Memo To: Jean Fraser  
Barbara Barhydt  
From: David Margolis-Pineo  
Re: Review Comments for 31 Fore St. – Proposed Four Unit Condominium

The Department of Public Works has the following review comments on the above project.

DRIVEWAY APRON LAYOUT DETAIL
NOT TO SCALE

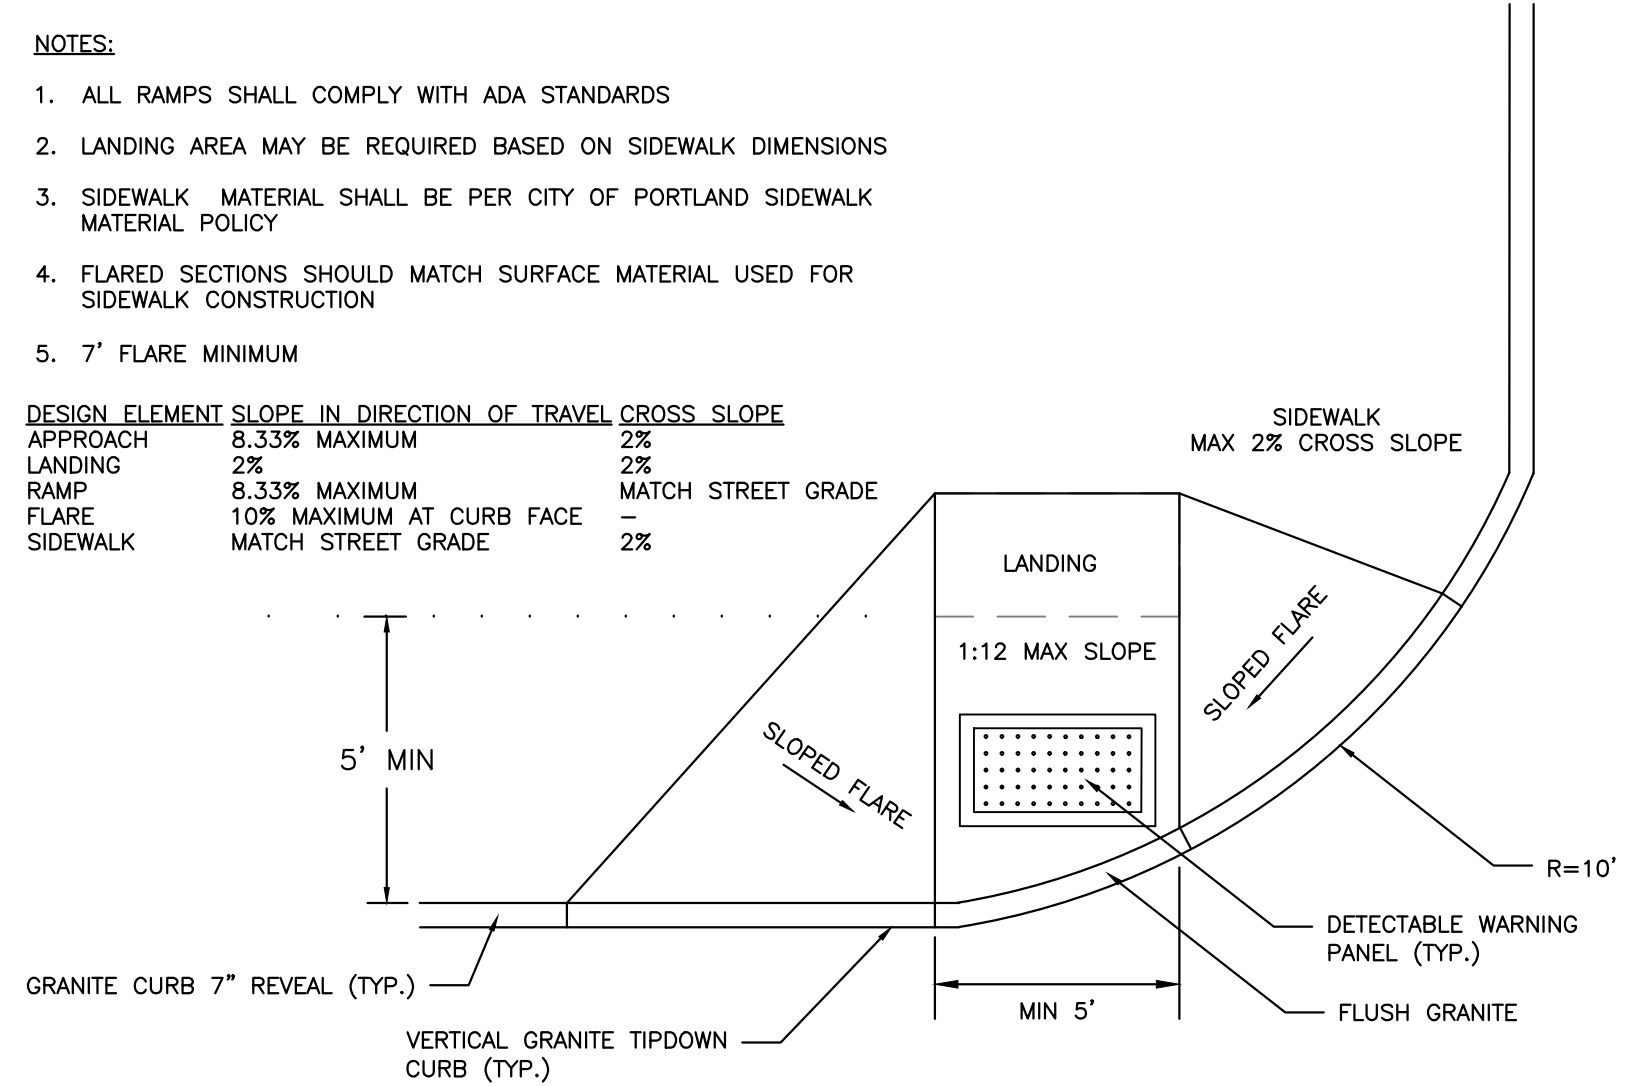
3. The proposed 12'-4" wide driveway on Waterville St. has an approximate 31' separation from the street corner as measured from the center of the drive to the street right of way (corner) of Fore St. Code requires 35'. Please try to make up the additional four feet by reducing the drive cut to 12', reduce the aisle width from 25'-8" to 24' and incorporate compact parking spaces (8' X 15') in an innovative manner. Thank you.
